Appeal NO: ABP 34485-22Defer Re O/H ☐Having considered the contents of the submission dated received 01/04/2024
fromRabbitte Group Properties Ltd. I recommend that section 131 of the Planning and Development Act, 2000
be not be invoked at this stage for the following reason(s): no new material issuesE.O.: Pat BDate: 17/04/2024

RE: Case number ABP-314485-22 Relevant Action Application Dublin Airport

Figure 13-10: 55 dB L_{night} Noise Contours, 2025 Relevant Action (orange), 2018 Baseline (blue), 2025 Baseline (yellow) and 2025 Consented (black)

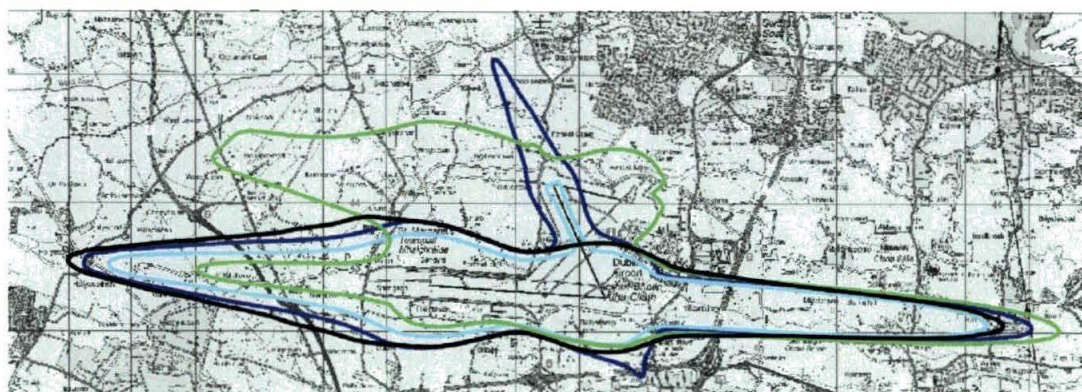
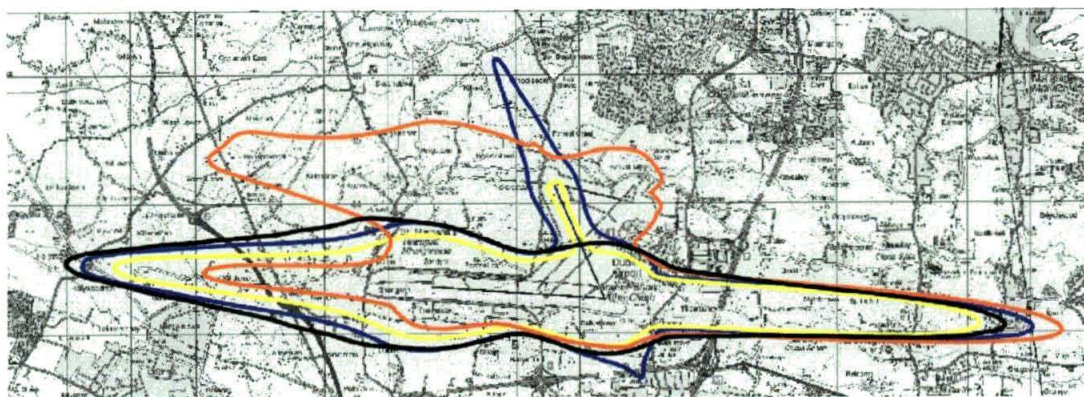
1. We are disappointed to see that the noise contours have extended hugely over the community of Coolquay and the surrounding areas. We note there was no notice to this fact in any of the planning notices for this application to date. Many residents who thought they were not affected by these contours were only made aware of it following a public meeting held by SMTW residents' group. These residents were not given the opportunity to make a submission / observation previously as they thought they were unaffected. An Bord Pleanála did not give public notice of this significant additional information. This is not acceptable and unfair to the communities affected.

4. Tom Phillips refers continuously to the regulatory decision by ANCA in his correspondence. However, they fail to include in their report that the proposal does not meet the Noise Abatement Objective of ANCA in future years. The proposed 2025 scenario will fail the NAO when compared to 2019 when the total of the existing population, permitted developments and zoned developments are summed together. "2025 exceeds 2019 by 4,541 people (1533 v 6074).
